Cambridge Waste Water Treatment Plant Relocation Project
Anglian Water Services Limited

Schedule of Amendments to the DCO Application

Application Document Reference: 1.8
PINS Project Reference: WW010003
APFP Regulation No. 5(1)

Revision No. 01
April 2023

Figure 1.1: Scope of the draft DCO and the future demolition and redevelopment of the site at Cowley Road

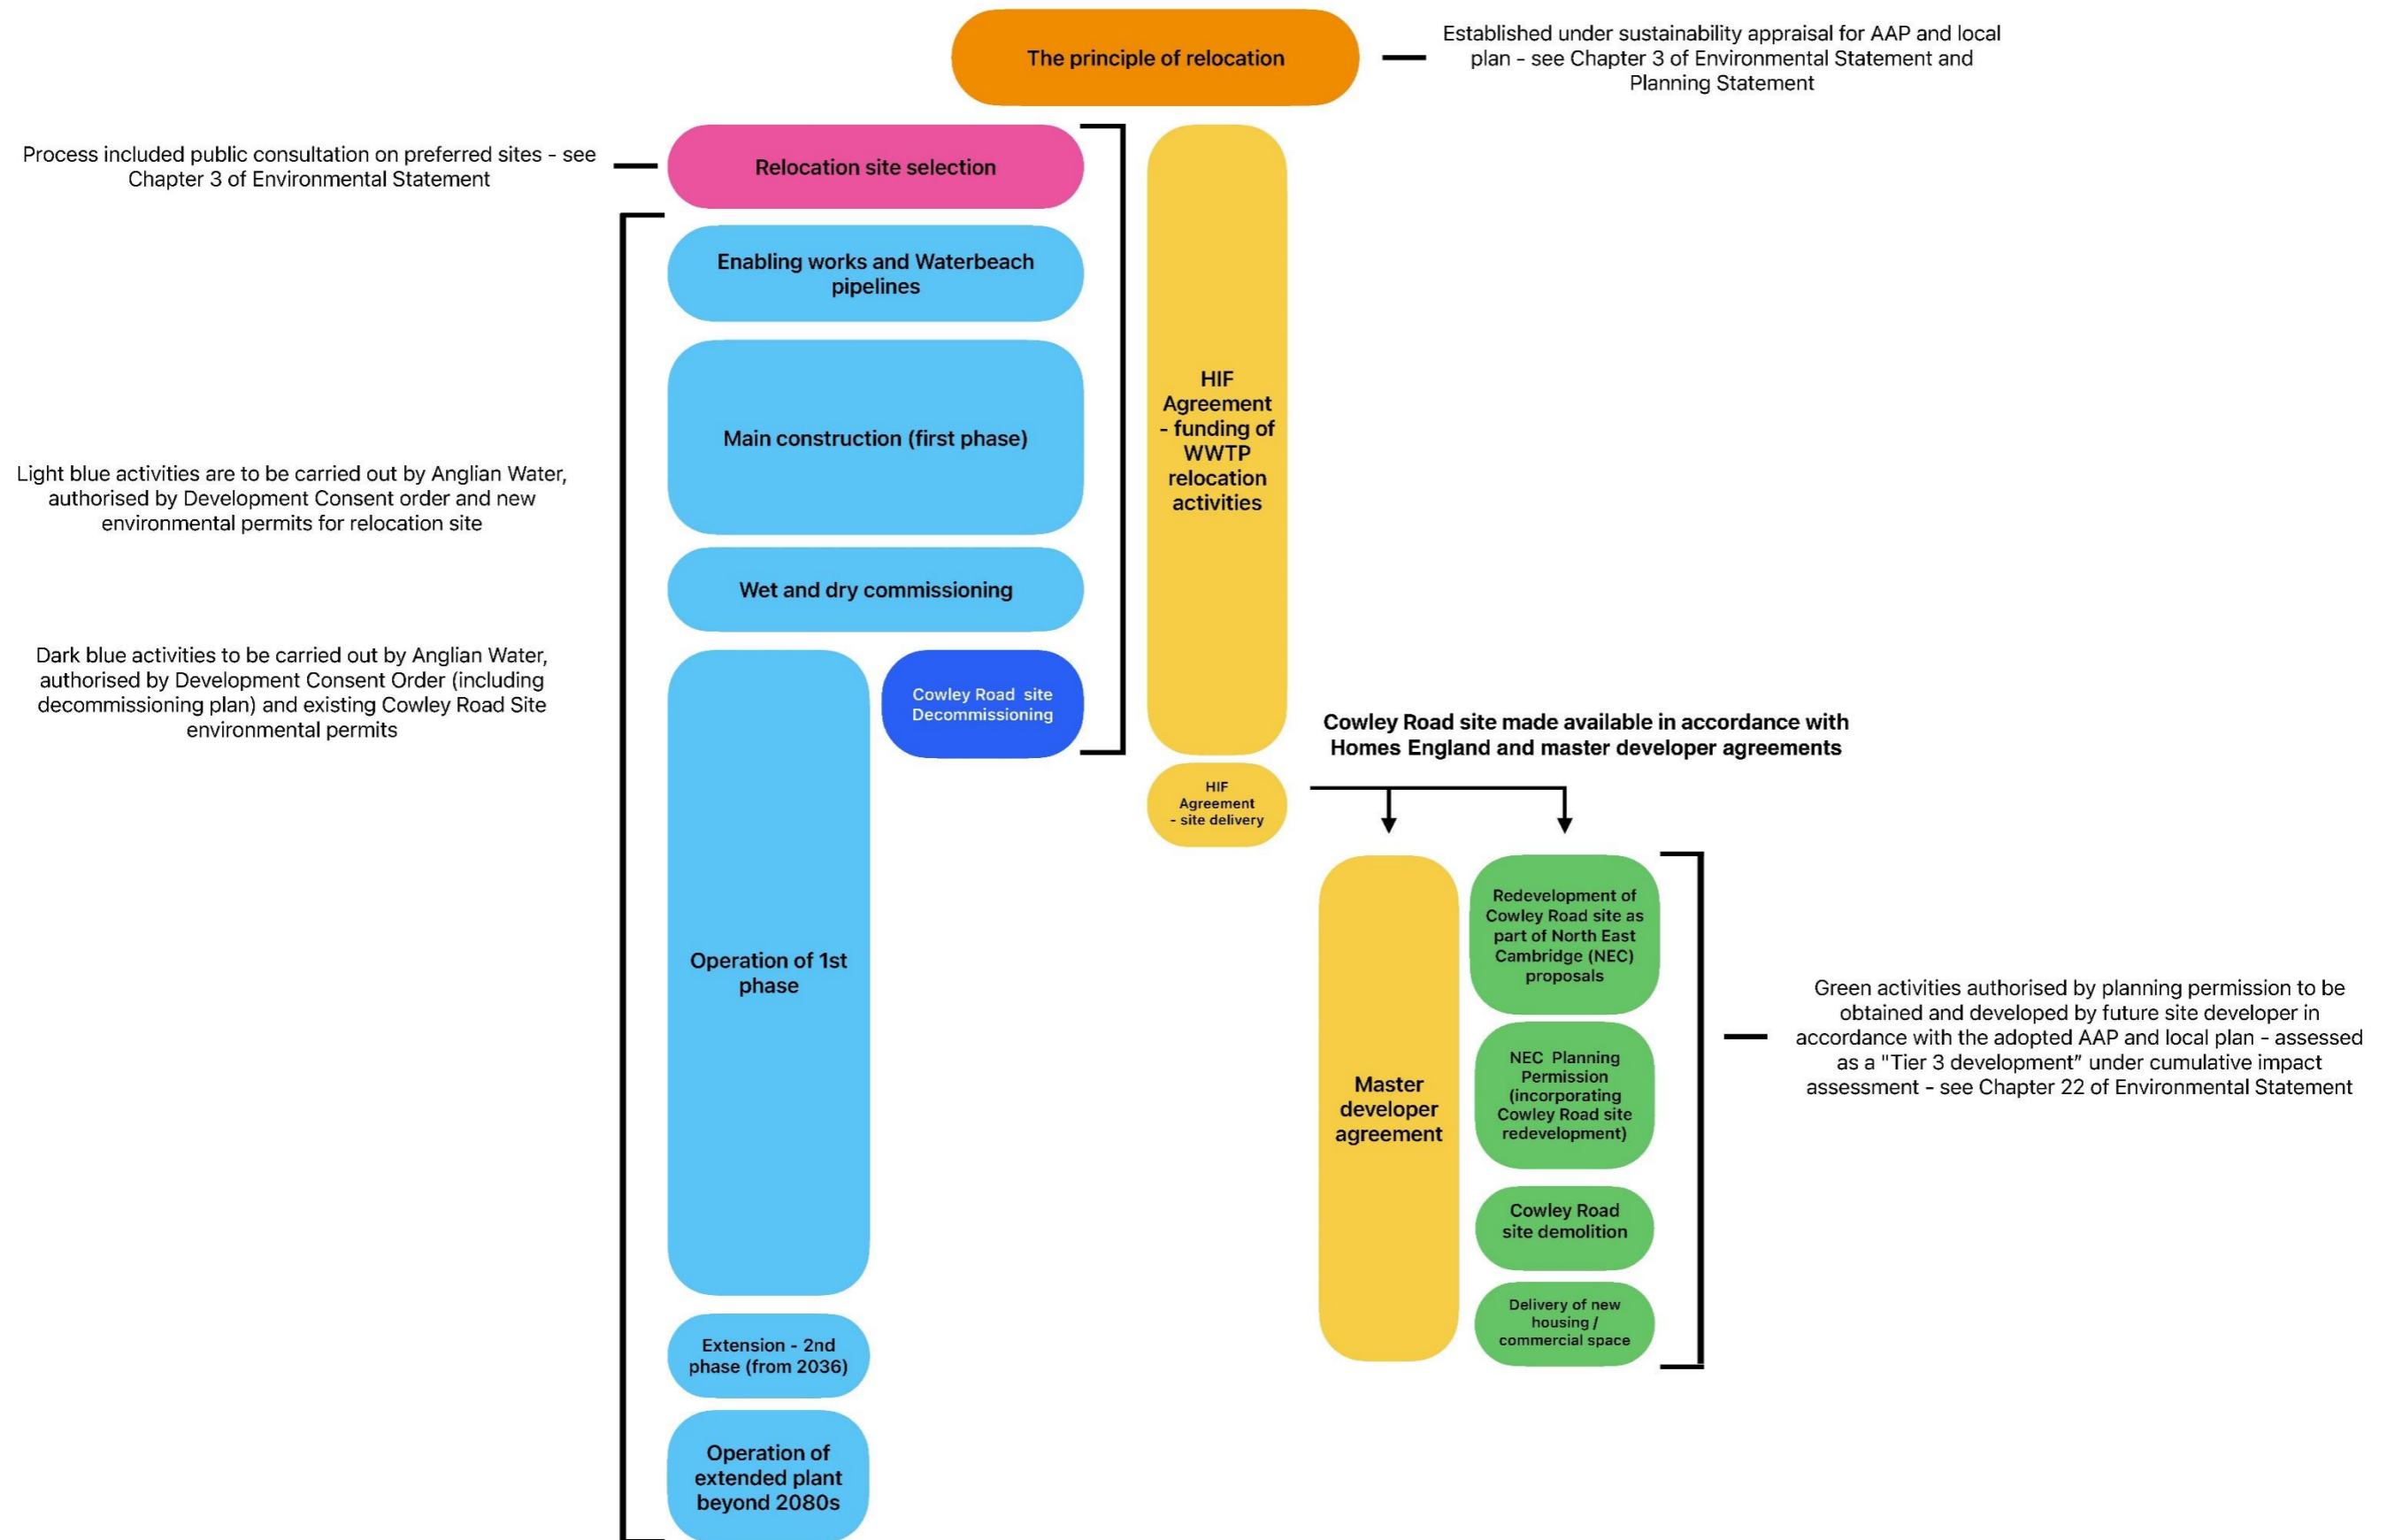
| PINs Reference | Section 51 Advice | Applicant Response and Document Reference(s) |
|---|--|---|
| <p>4: Para 3.4, Chapter 2, Project Description, ES (Doc 5.2.2)</p> | <p>Scope of the PD and EIA: 3.4 describes the decommissioning activities at the existing Cambridge WWTP and how the assessment took account of them. This leaves a clean, disconnected works. The Applicant is advised to consider whether total remediation and demolition should be considered as part of the PD assessment, or at least as part of a cumulative assessment, up to making the site suitable for redevelopment.</p> <p>It is noted that the cumulative effects chapter of the ES (Ch 21) simply states: ‘<i>Redevelopment of the existing Cambridge WWTP would be subject to separate consents and supported by an assessment of environmental impacts including the development of mitigation measures. These measures would cover demolition activities and be controlled via a CEMP/CTMP.</i>’</p> | <p>Please see the response above. The applicant does not consider that the demolition and remediation form part of the project. They will not be undertaken otherwise than as part of the comprehensive redevelopment of the existing site, and therefore form part of that project. For the reasons set out above, the applicant confirms that that redevelopment has been considered as part of its cumulative assessment. See further explanatory text added to ES Chapter 2 section 1 and figure 1.1</p> <p>Please see the response above.</p> |
